**Great North Road Solar and Biodiversity Park EN010162
Post Hearing Submission from Nottinghamshire County Council
18th February 2026 (Examination Deadline 3)**

Nottinghamshire County Council (NCC) submits the following post hearing statement at Deadline 3. This statement is a written summary of the oral representations made by NCC at the hearings held during week commencing 2nd February 2026, supplemented with further clarification where necessary.

Passing Place Locations  
Figure 14.5 SE

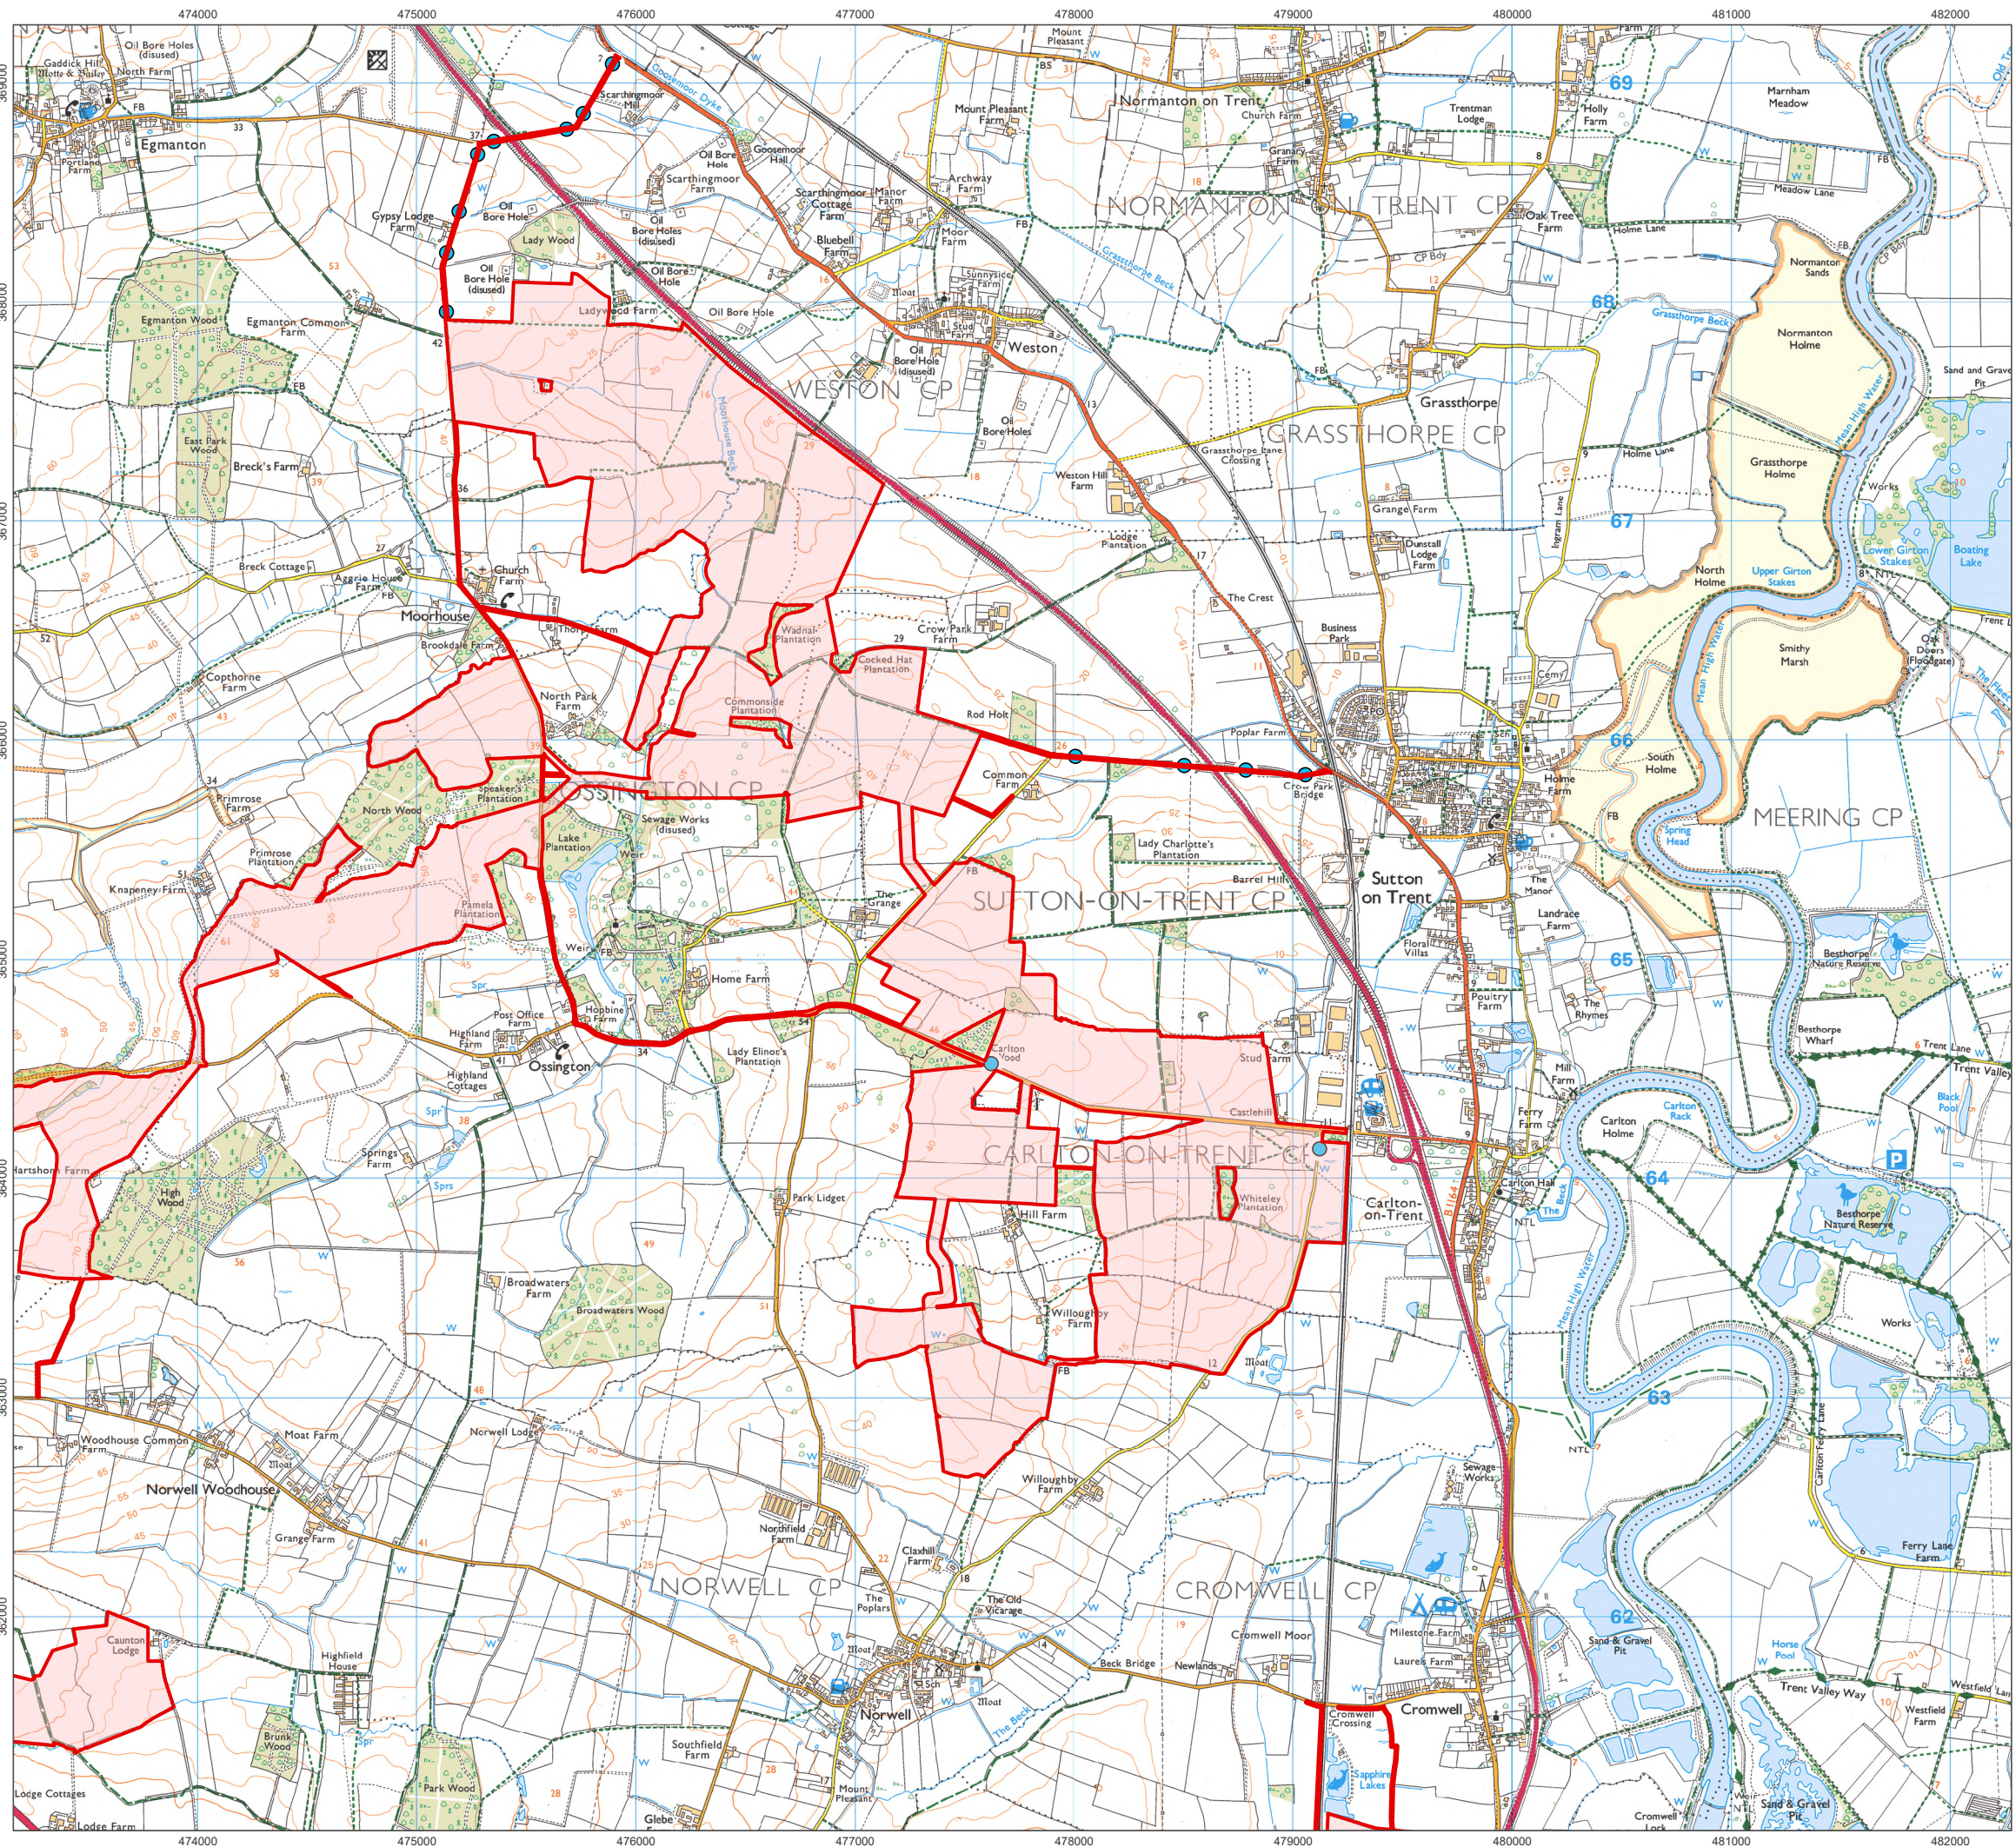
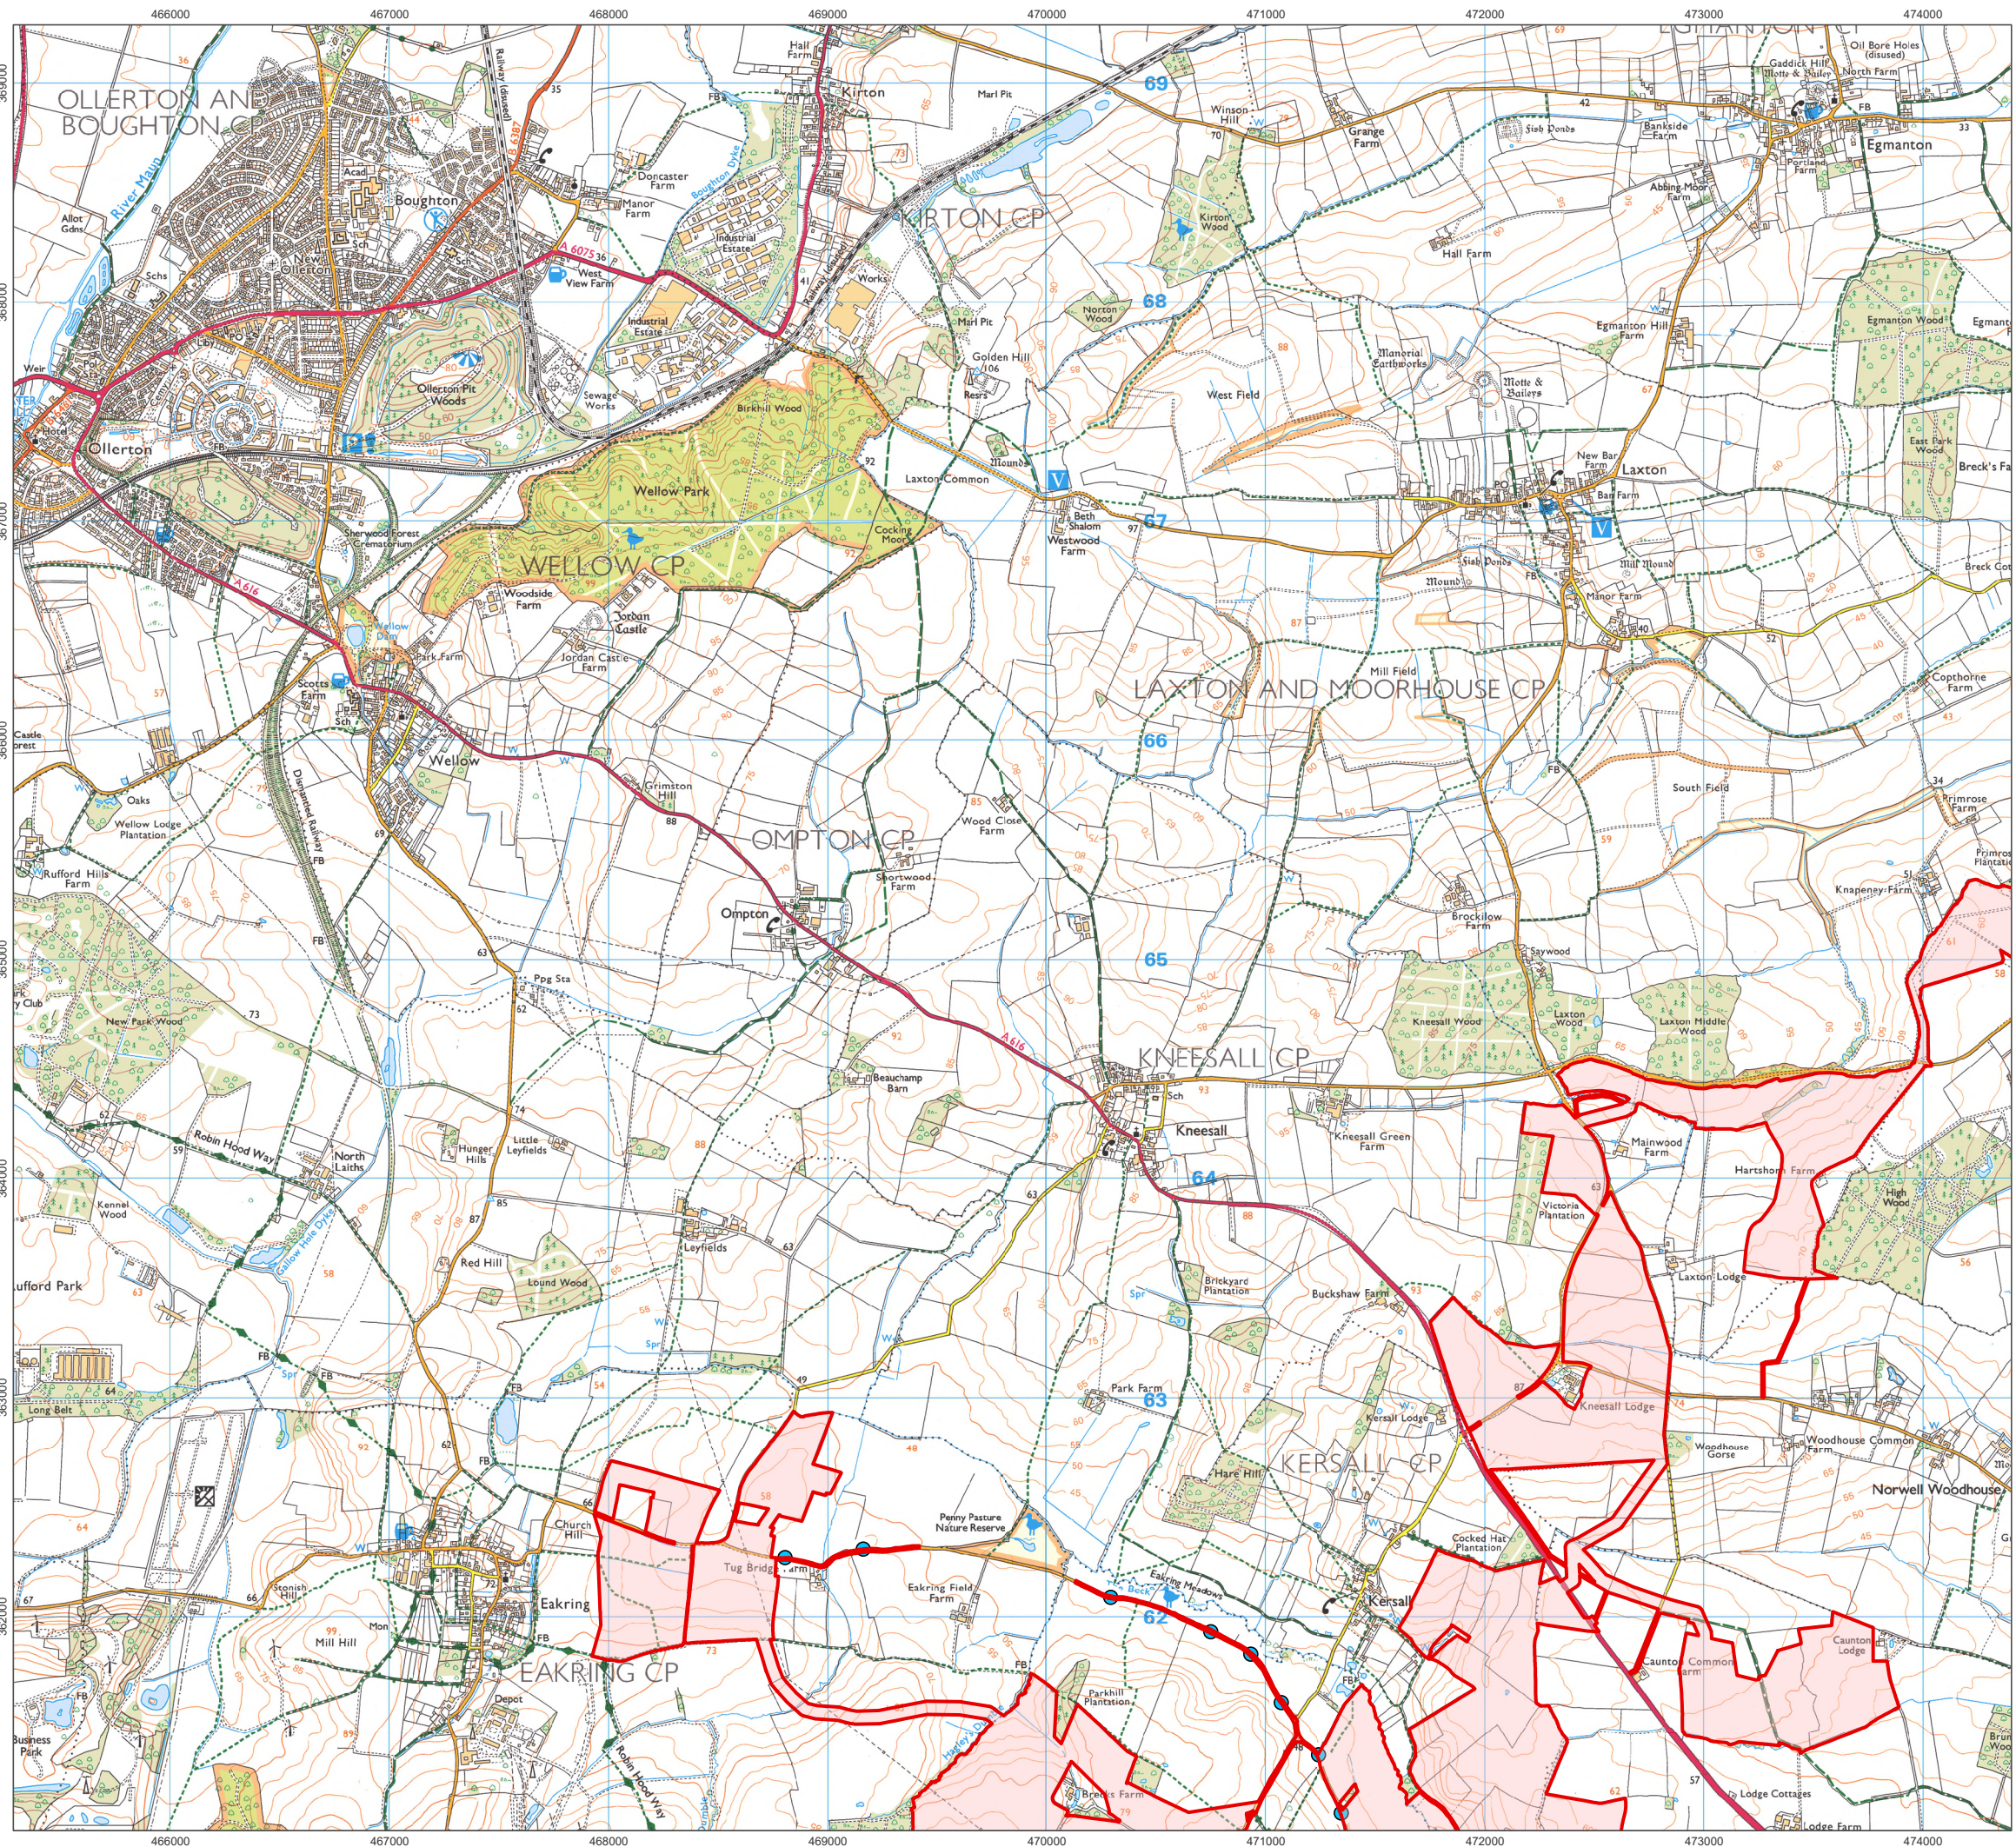
16. NCC recommended that all passing places to be installed on the highway are permanent, rather than temporary as proposed. This is because they are a necessary feature of the operational phase (to facilitate HGV access for replacement of the solar panels) as well as the decommissioning phase.
